**WELWYN HATFIELD BOROUGH COUNCIL
EXECUTIVE DIRECTOR - PLANNING, PUBLIC PROTECTION AND GOVERNANCE**

DELEGATED APPLICATION

Application No: 6/2022/2302/EM
Location: 5 Densley Close, Welwyn Garden City, AL8 7JX
Proposal: Garage and loft conversion with rooflights to provide living accommodation, alterations to openings, replacement windows and doors, Installation of solar panels to modified garage roof and installation of EV charger to garage side wall, new side access gate and related paving, new shed to rear garden.
Officer: Mr James Homer

Recommendation: Granted

TITLE  
**PROPOSED  
 BLOCK PLAN**

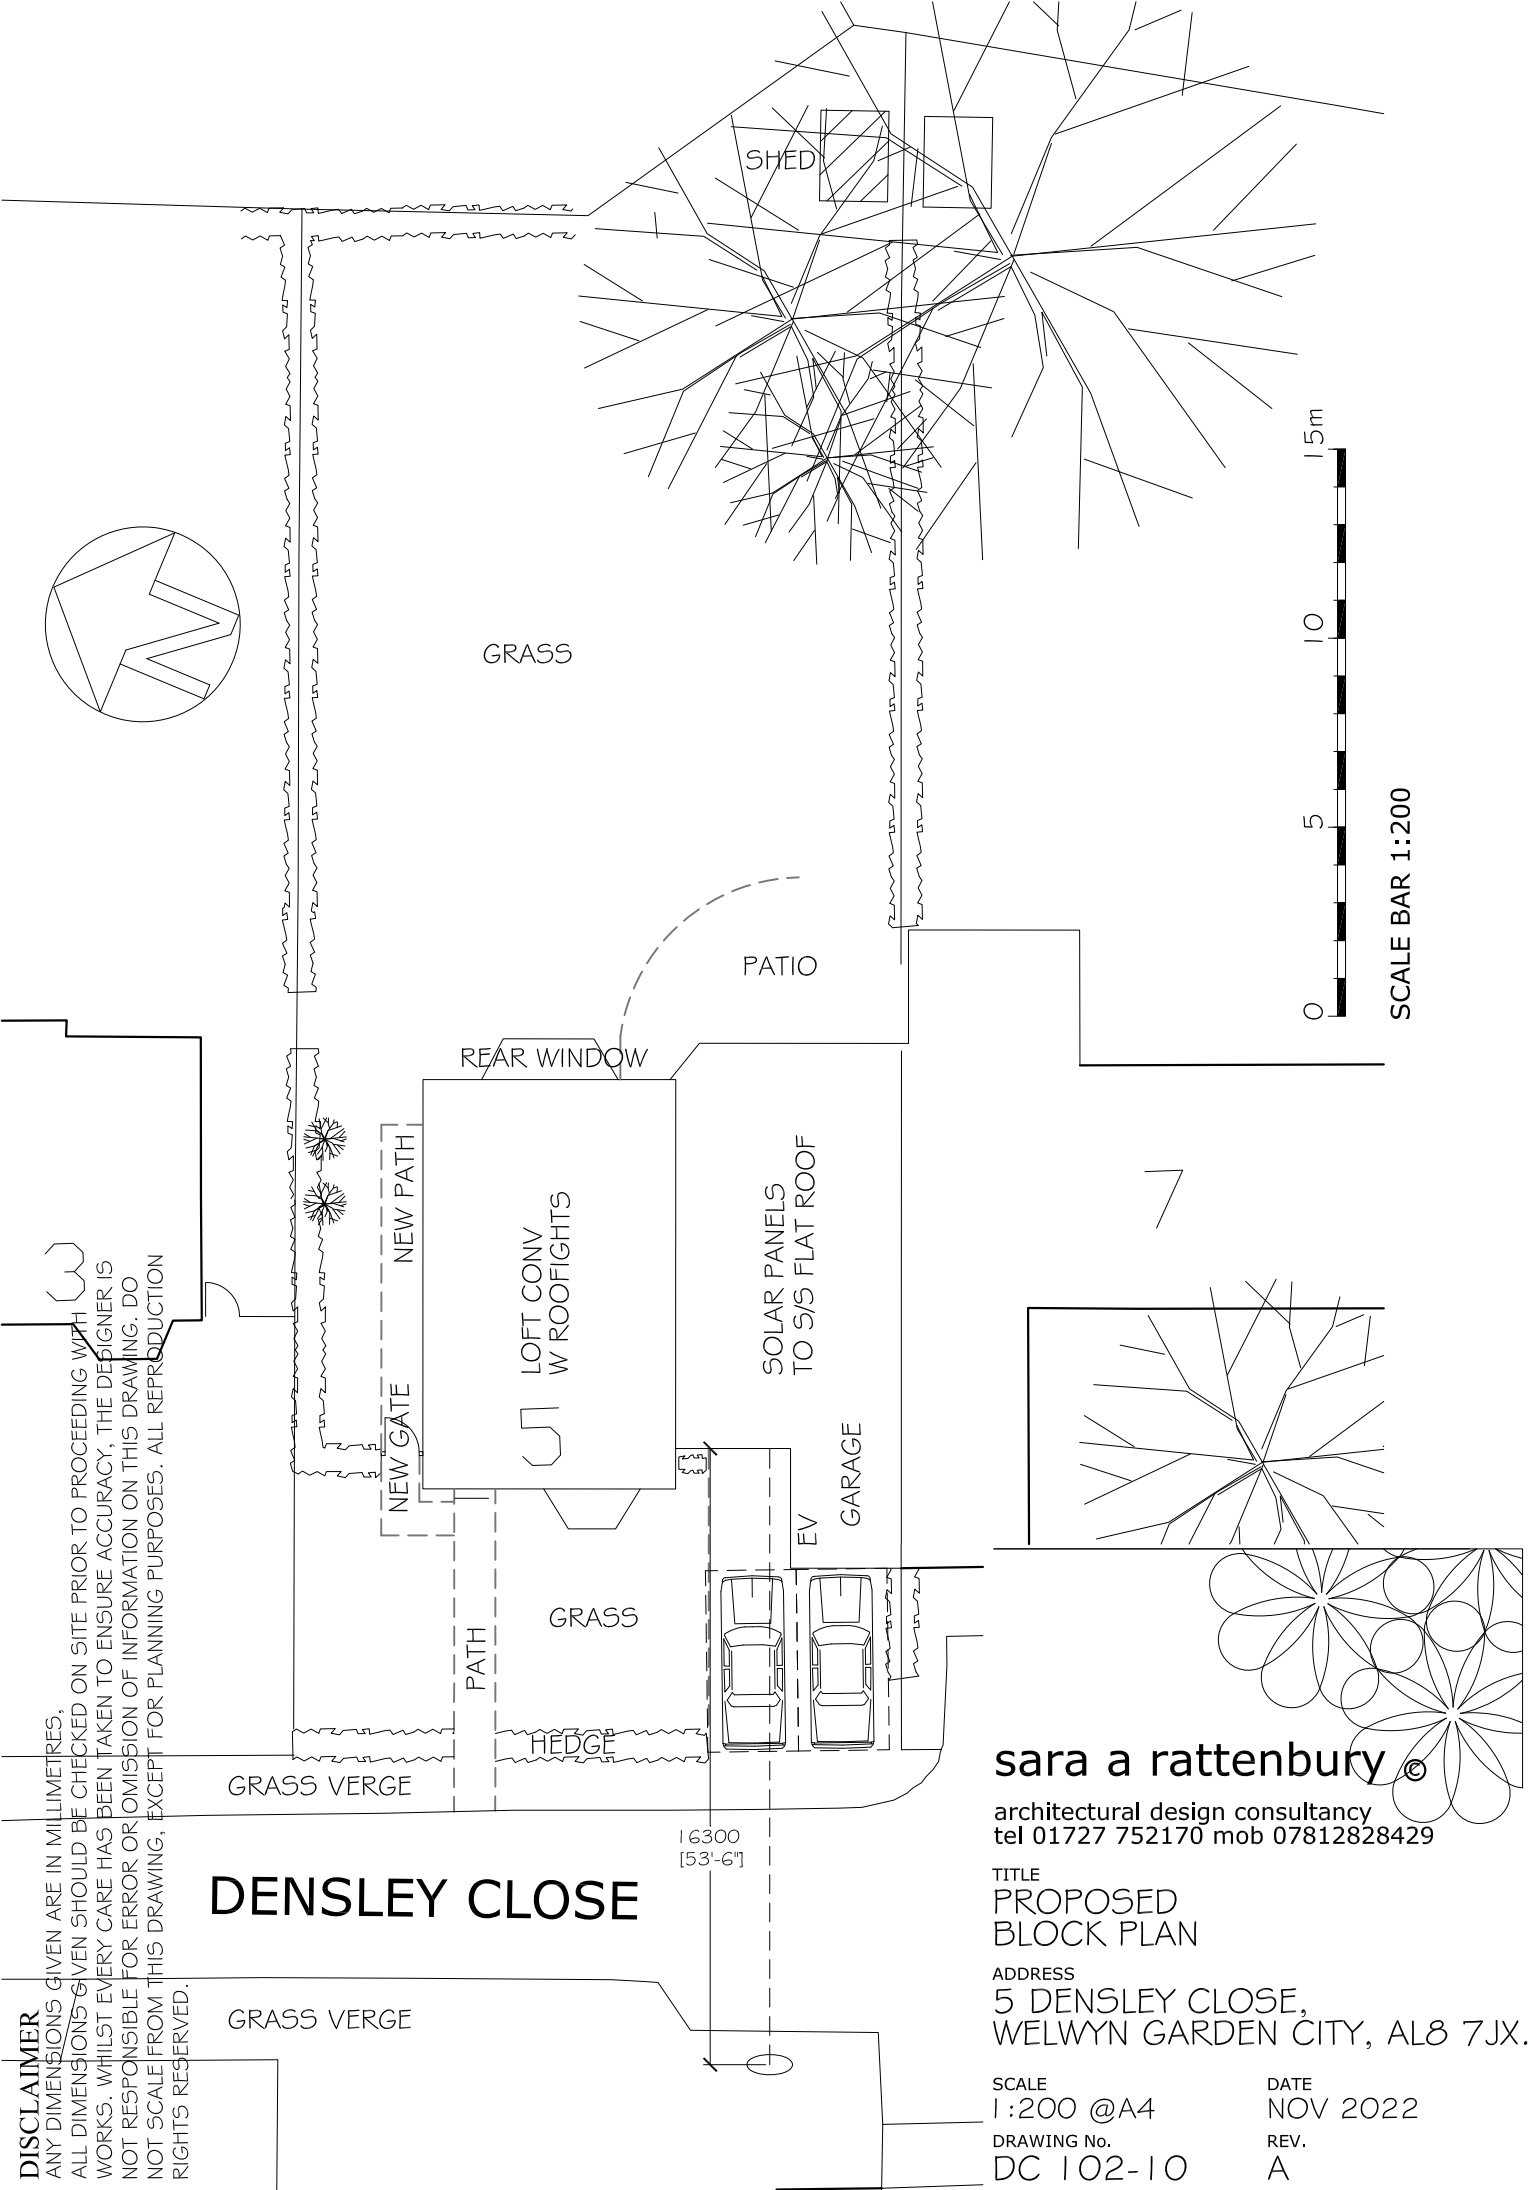
<p>Landscaping issues (incl. hardstandings)</p>	<p>The application proposes to create a new access to the rear garden by removing a section of hedgerow to the side of the main house and installing a gate. A route to the gate will be created by installing a footpath from the front of the house to the new access point. Only a minimal section of hedgerow would be removed to allow a gap for the gate and the additional hardstanding upon the front for the formation of the path would not result in a harmful loss of green landscaping.</p>

6. Only that part of the hedge identified for the approved gate access shall be removed and the remainder shall be retained.

TITLE
**PROPOSED
PLANS & ELEVATIONS**
ADDRESS
5 DENSLEY CLOSE,
WELWYN GARDEN CITY, AL8 7JX.
SCALE 1:100 @A2 UNLESS OTHERWISE STATED DATE NOV 2022
DRAWING No. DC 102-1 REV. B

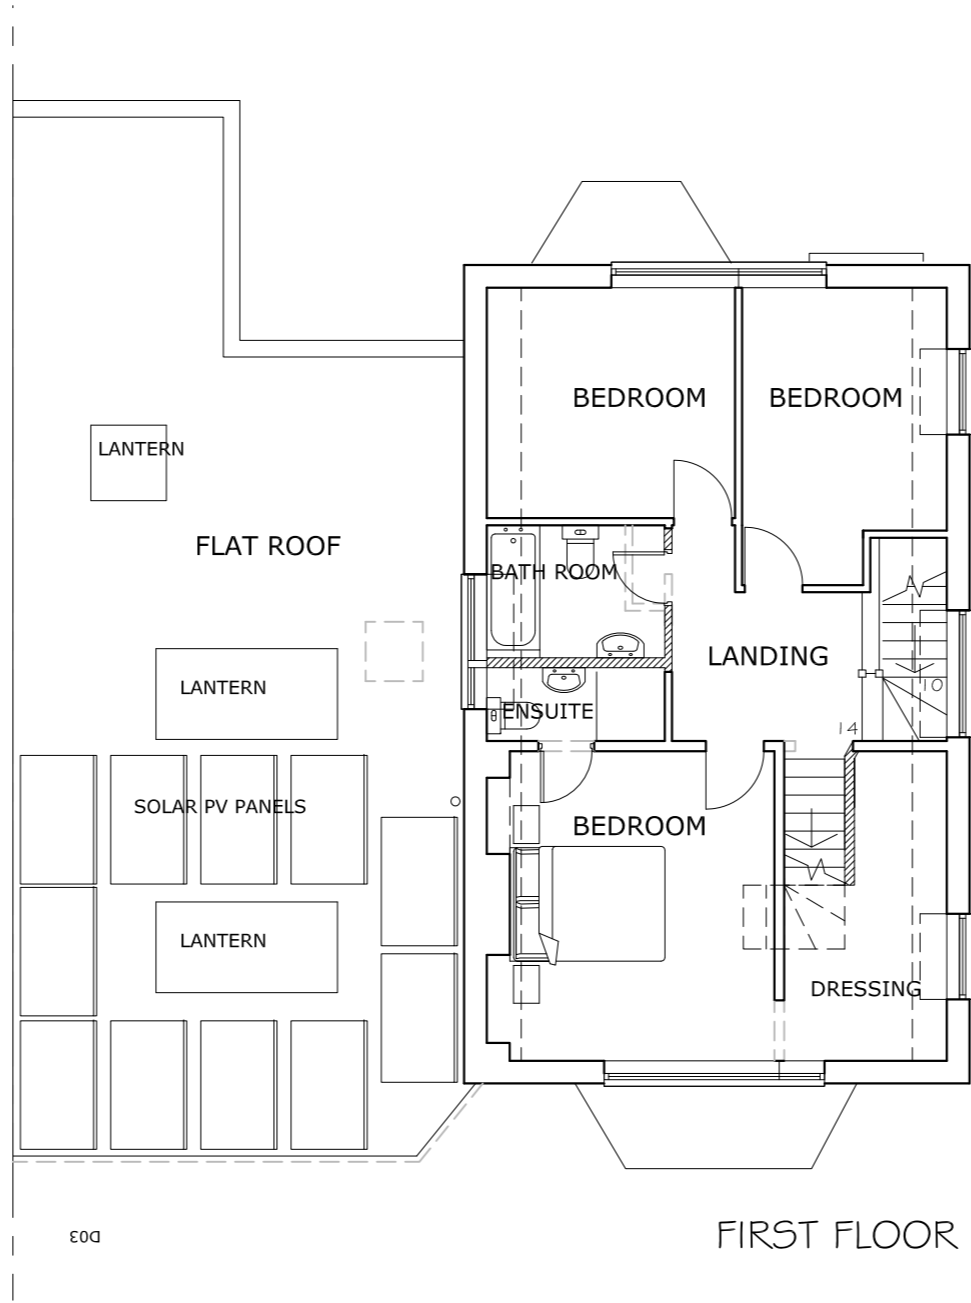
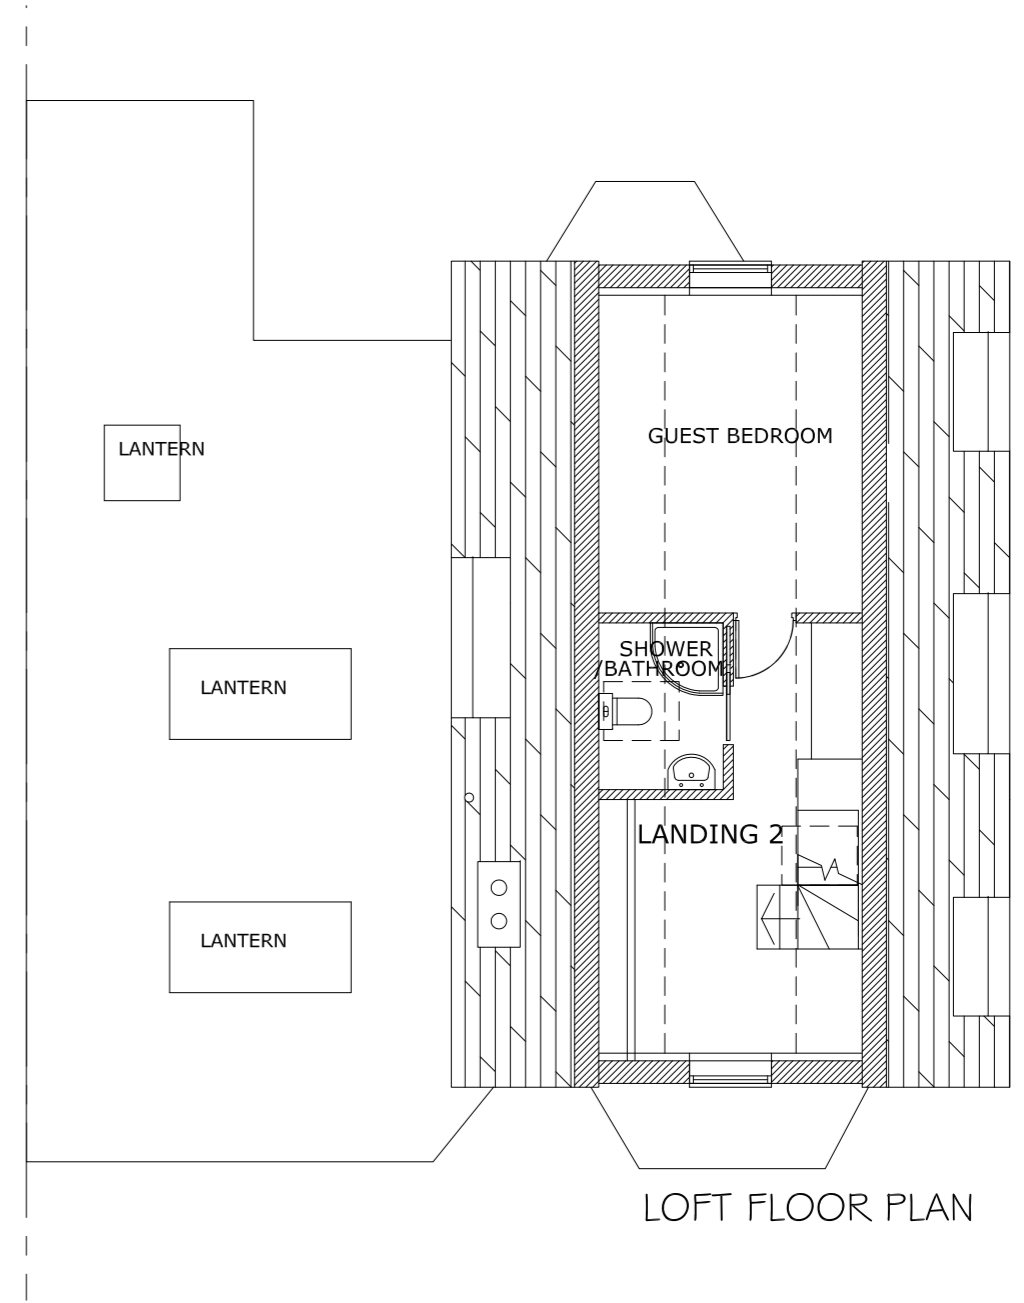
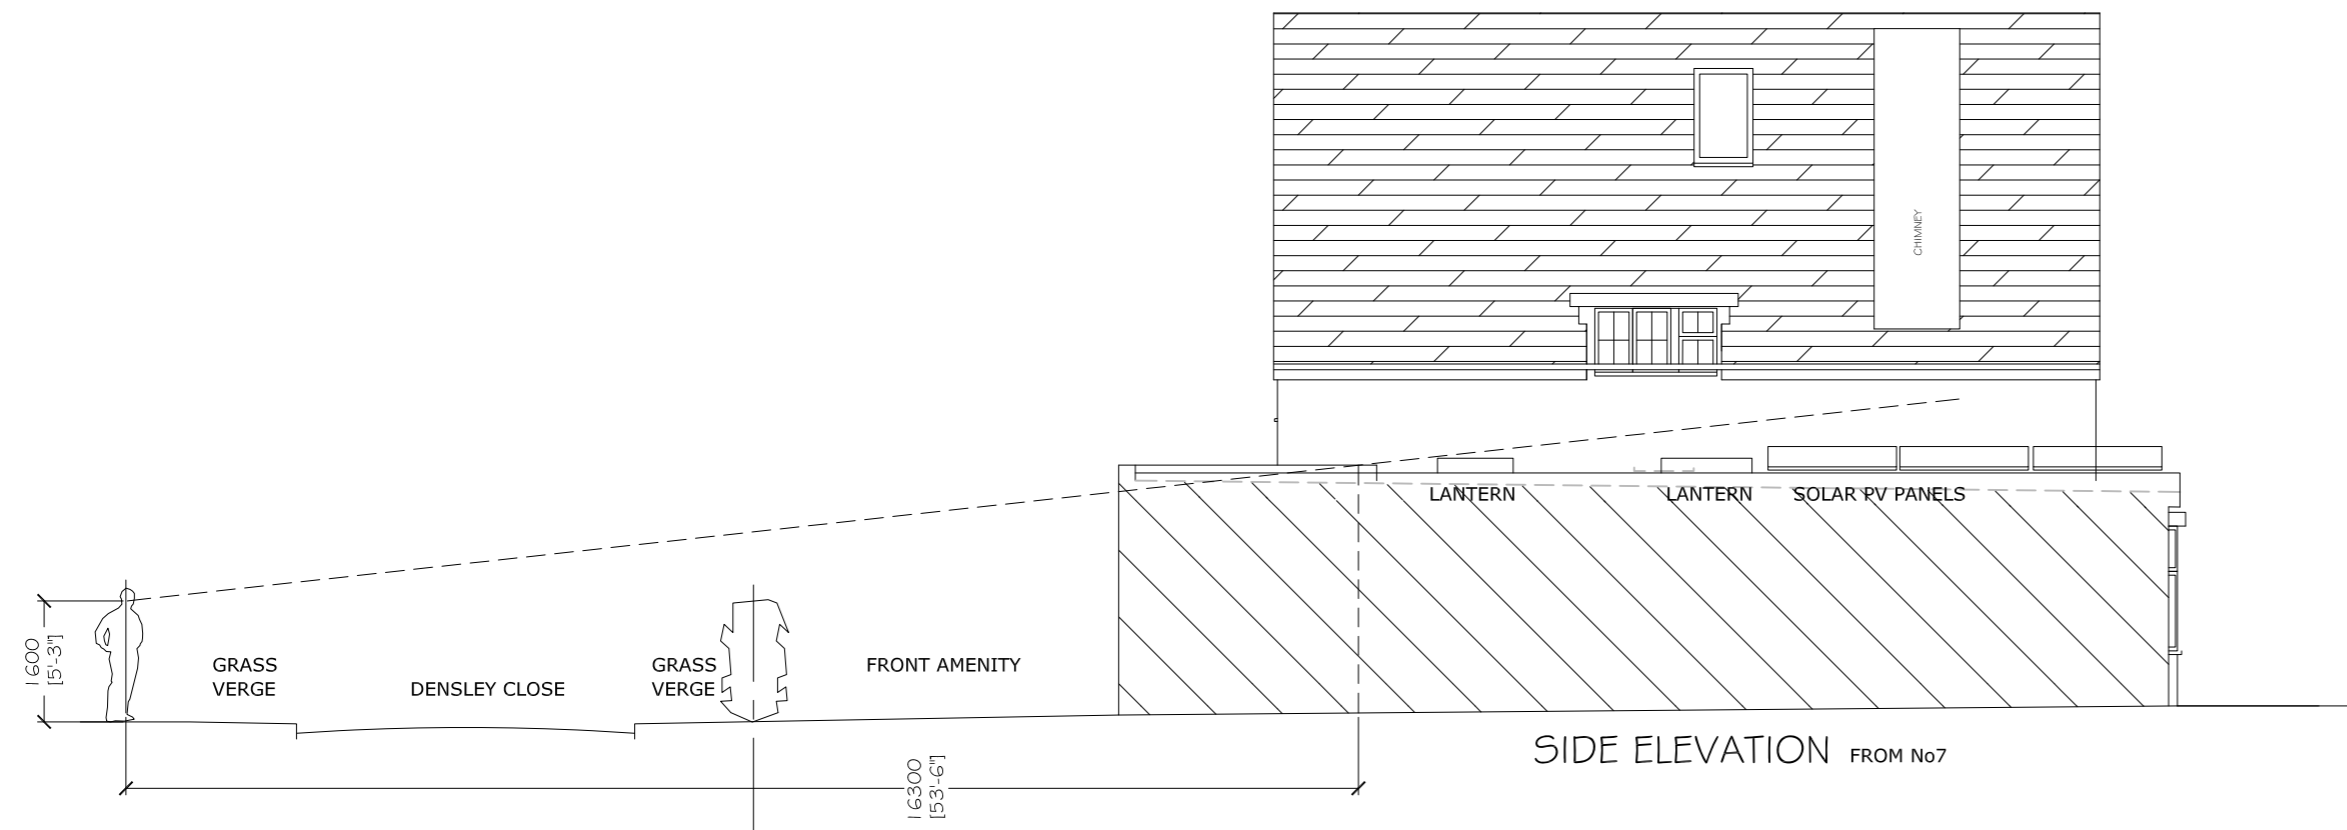
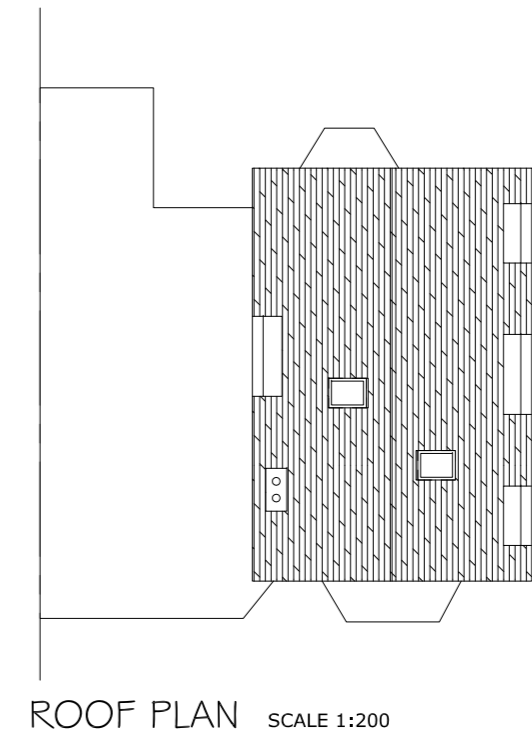
To enable the part conversion of the existing garage, the application proposes to raise the height of the garage roof to allow sufficient insulation to be installed. The increase in height would be relatively minimal and would not result in significant change. The replacement roof would also feature three new roof lights that although slightly proud of the roof, are unlikely to be unduly visible from the street at the front of the property. The front of the garage would be retained as a storage area and the existing up-and-over door would be replaced with two hinged doors with high level glazing. The replacement doors would reflect the character of the property and wider area.

The application proposes to convert the existing loft space into habitable accommodation. To facilitate this change, single Velux standard roof lights are proposed for the north and south facing roof slopes of the main house. Each roof light is set toward the rear of the property but would remain visible from the street. To ensure the impact of the roof lights is minimised it is considered reasonable and acceptable to include a condition to the decision notice that requires the rooflights to be conservation style. This will help ensure the roof lights are fitted as flush as possible to the roof slope. In addition, a new window opening is proposed for the front and rear gable ends of the property. Although not an original feature, new window openings within gables to allow loft conversions has been considered acceptable in the past and the matching style of the proposed frames will ensure the additional windows are in keeping with appearance of the property. It is also worth noting that a gable window can be seen at 10 Densley Close.

The application proposes alterations to existing window and door openings. At the rear of the property, two windows are to be removed, the opening made larger and bi-folding doors installed. The bi-folds will not be visible from public areas and no objection is raised regarding their inclusion. At the front of the property, two crittall style windows either side of the side access door are to be removed and replaced with double glazed like-for-like replacements. The application also includes a replacement window for the first-floor bathroom. The plans show this would match the existing style and is considered acceptable.

Tilted solar panels are proposed for the rear section of the garage roof and existing ground floor extension. The installation of solar panels is covered by Policy EM5 of the Estate Management Scheme. At present, Policy EM5 of the states that consent will only be granted for energy efficiency measures and other roof alterations where they are sited on the rear or side roof slope and are sited to minimise the effect on the external appearance of the building. However, considering the climate emergency the council declared in 2019, the council has recently updated its position regarding solar panels, and it has been agreed that they should now be allowed on front facing roof slopes. It is important that proposals for solar panels on front elevations follow the same criteria that has been established for rear facing installations. It is important that proposals for solar panels on front elevations follow the same criteria that

7. With the exception of the ground floor rear facing windows, all other external window frames, glazing bars, sills, door, door surrounds and other external decorations associated with the fenestration hereby approved shall not be any colour other than white.

8. All rooflights hereby permitted shall be conservation style rooflights set as flush as practicable within the roof slope.
